OUT20/11063

**Mixed use development at 8-16 Watt Street Gosford (SSD 10414)  
EIS**

1 TYPICAL BASEMENT PLAN (LEVELS B2-B5)
DA534 1 : 500

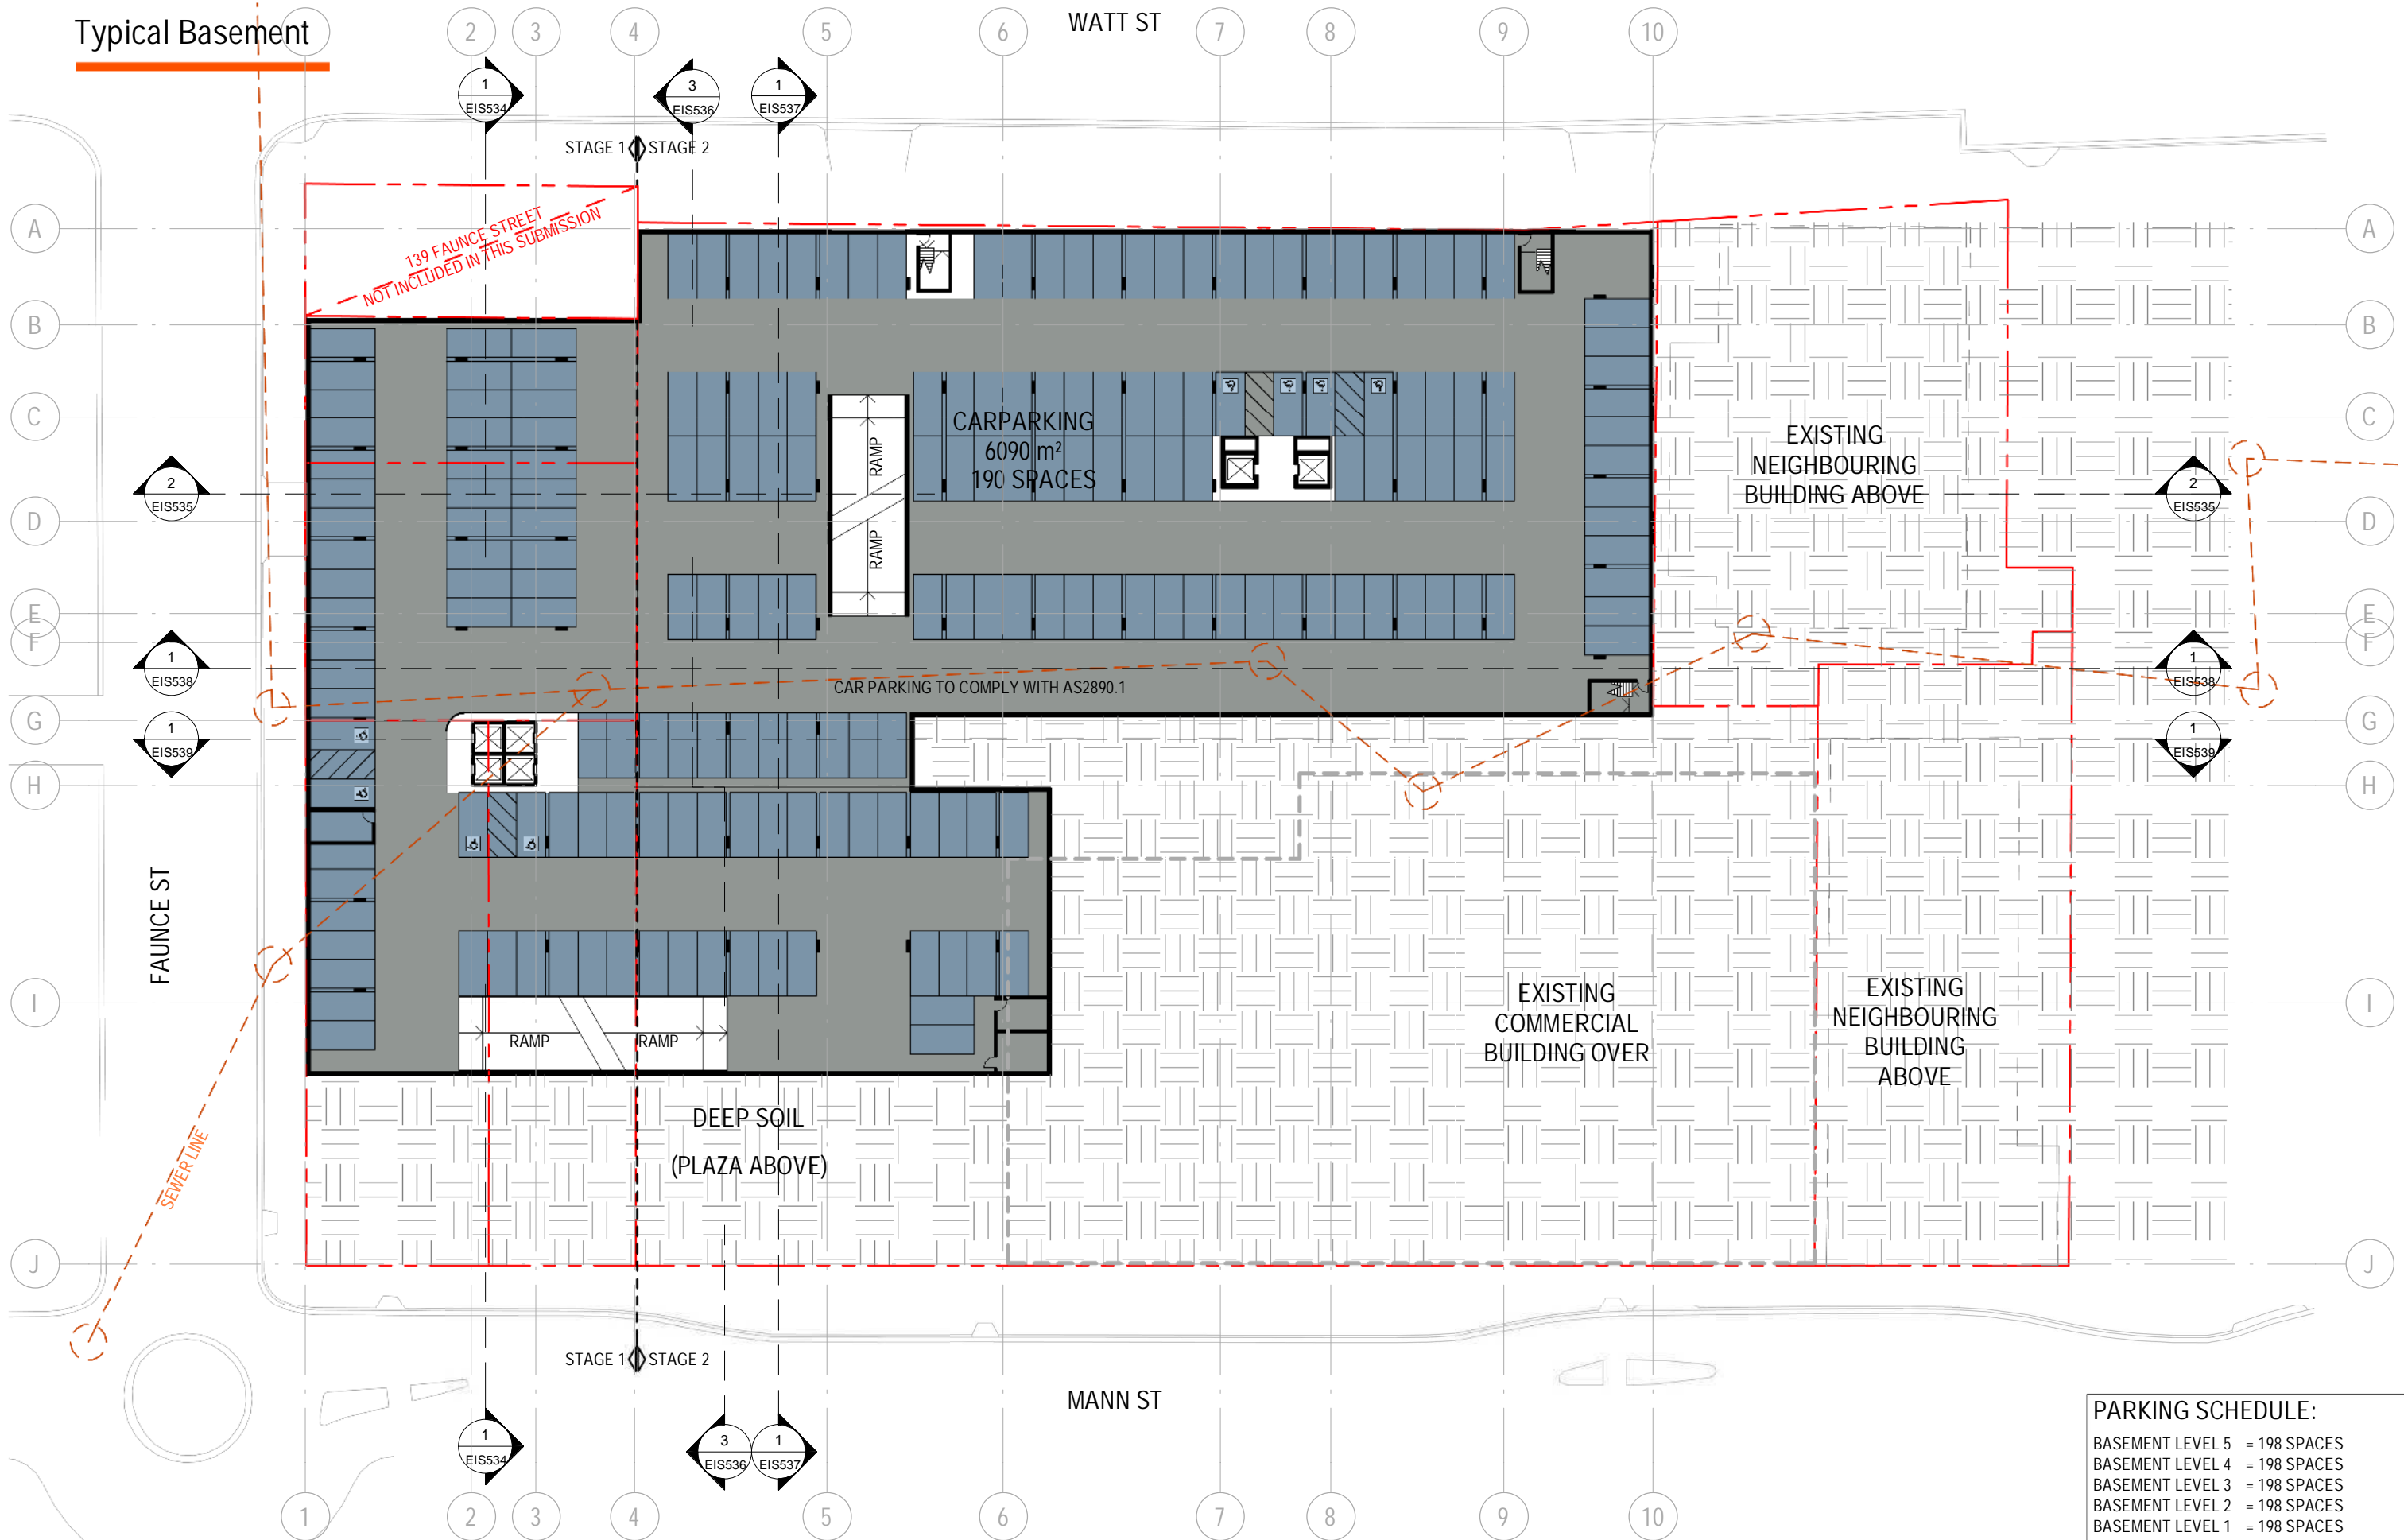
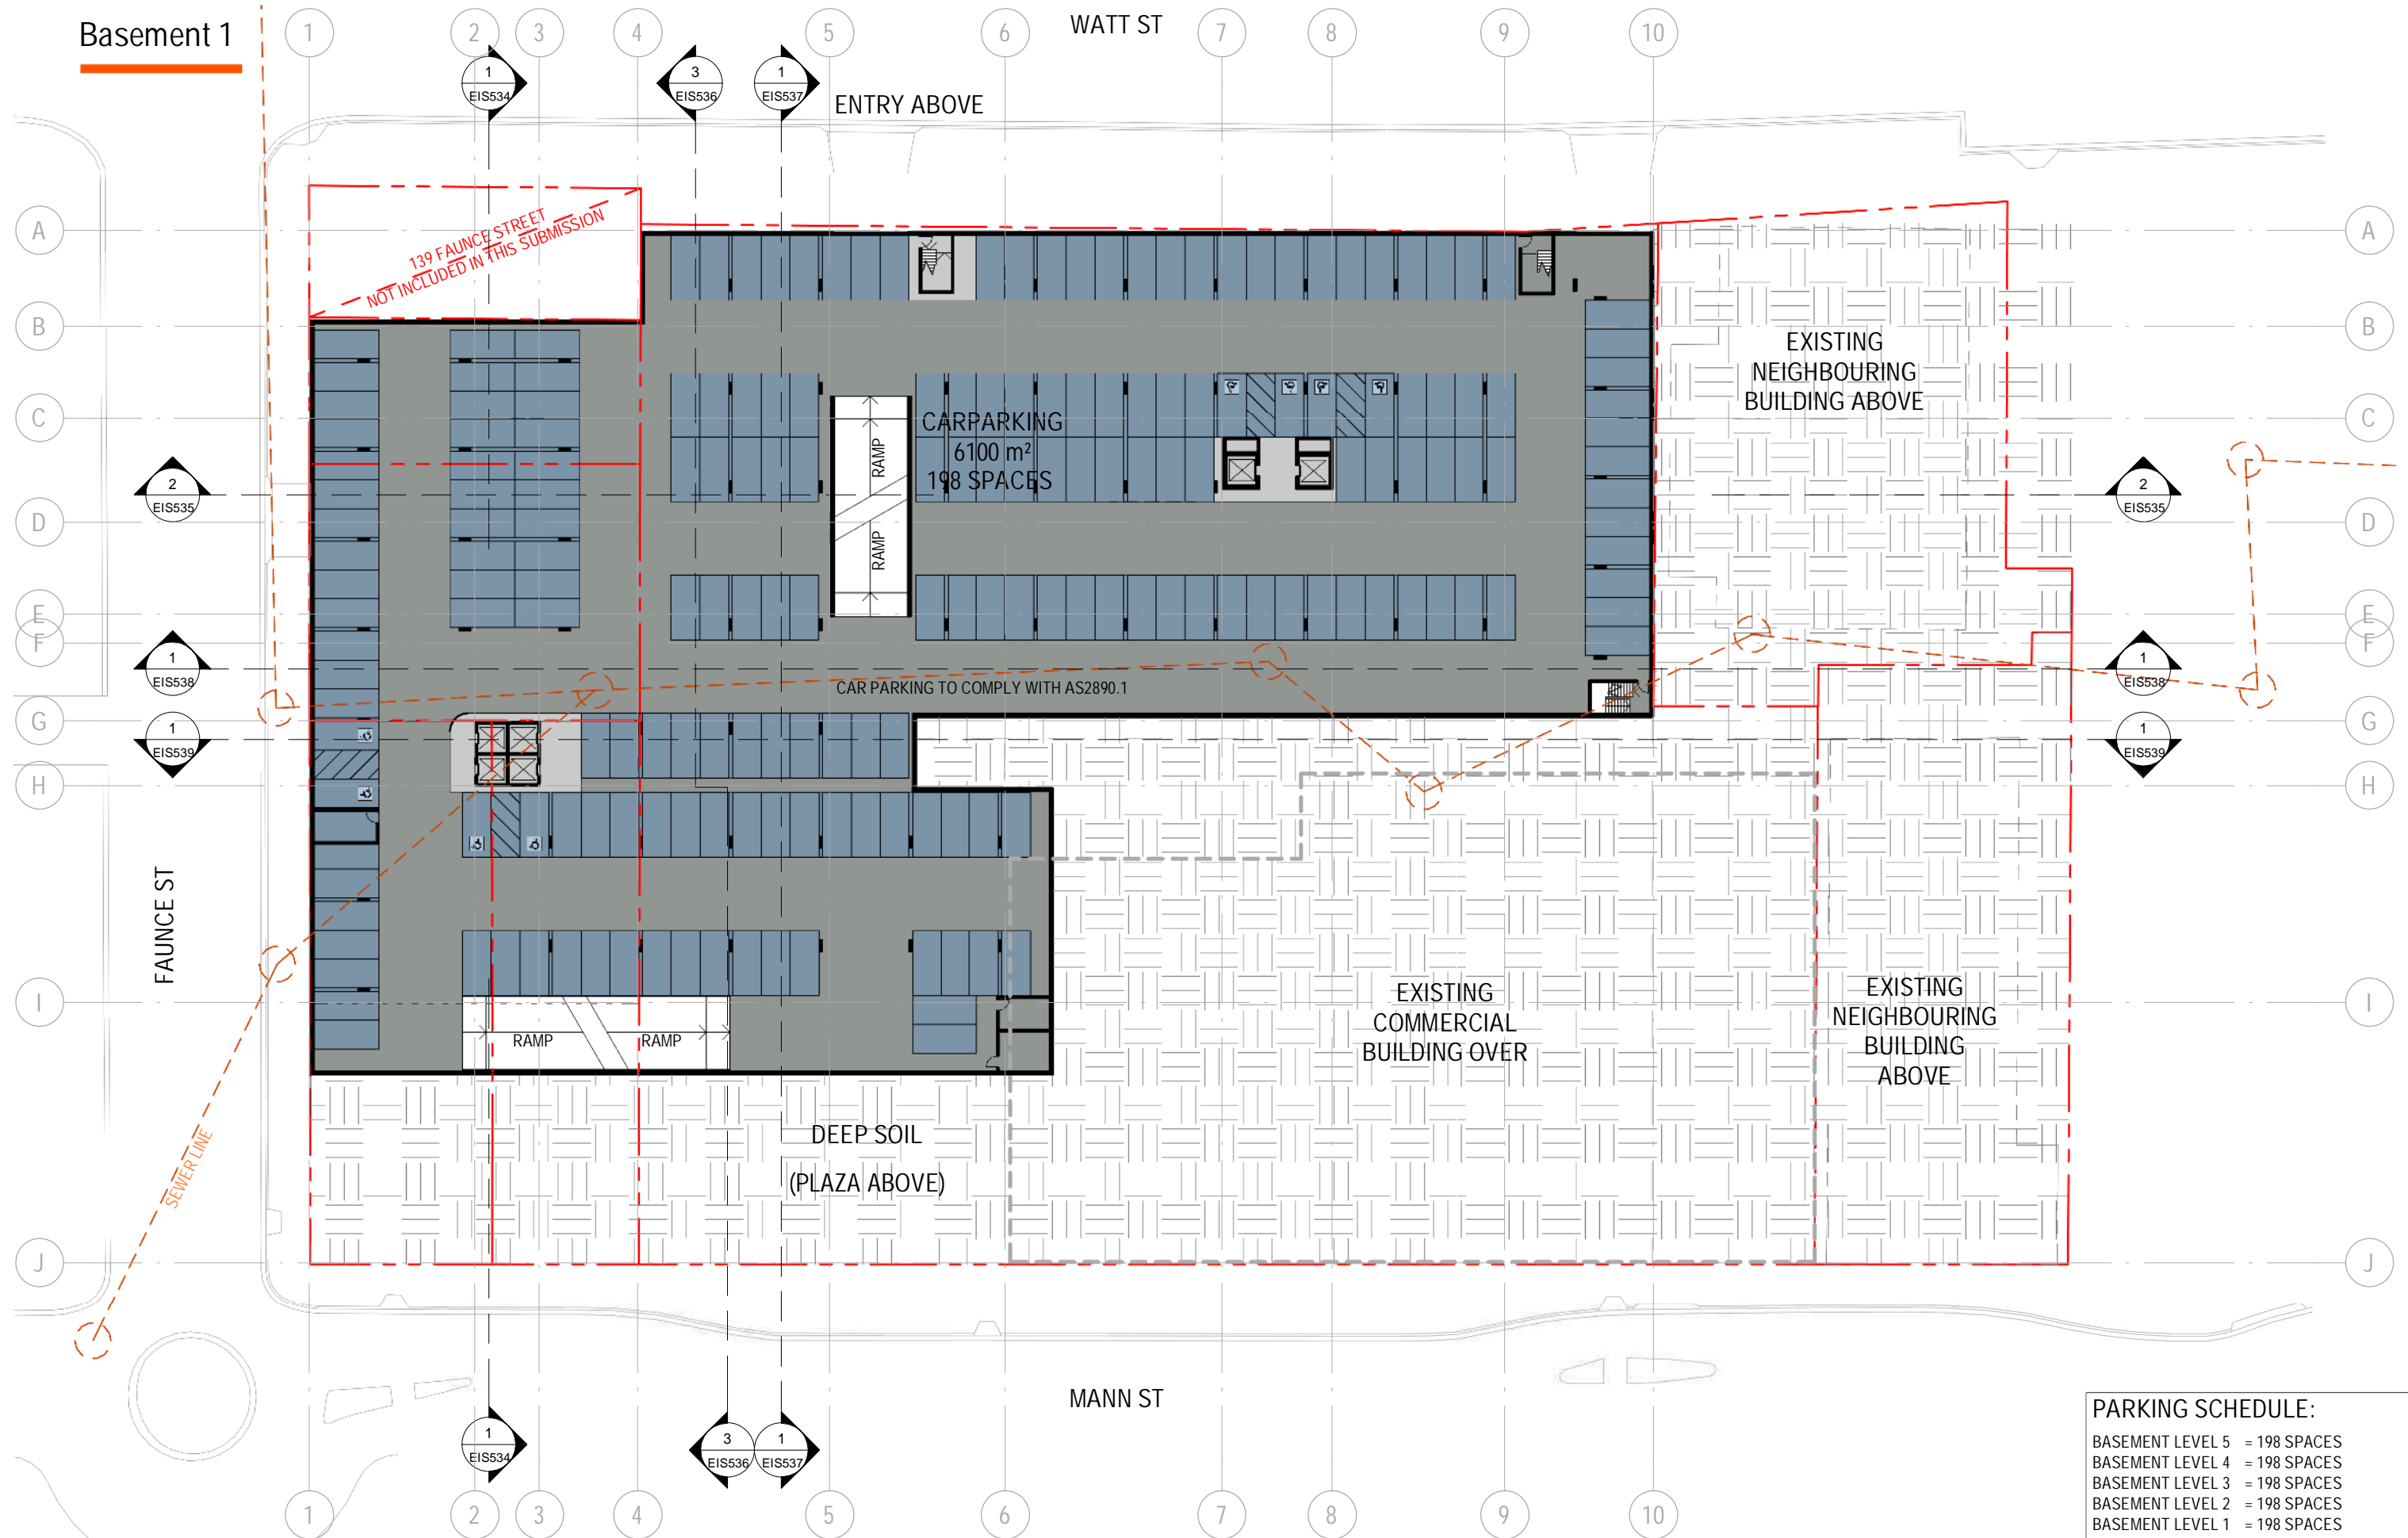
The EIS describes a relatively shallow water table, within a sandy clay alluvial formation, and recommends a tanked-basement system in the event that a basement is incorporated into the final design. Given the development application is at concept stage, the final design has not yet been proposed. We believe that should a fully tanked basement be required, the water take would likely require licencing for the duration of excavation and below ground construction.

- If the final design incorporates a basement it should be designed as fully-tanked based on shallow depth to water and likely presence of unconsolidated, high-permeability formation. This will reduce the future burden of operational requirements as well limiting potential groundwater impacts to the duration of construction.
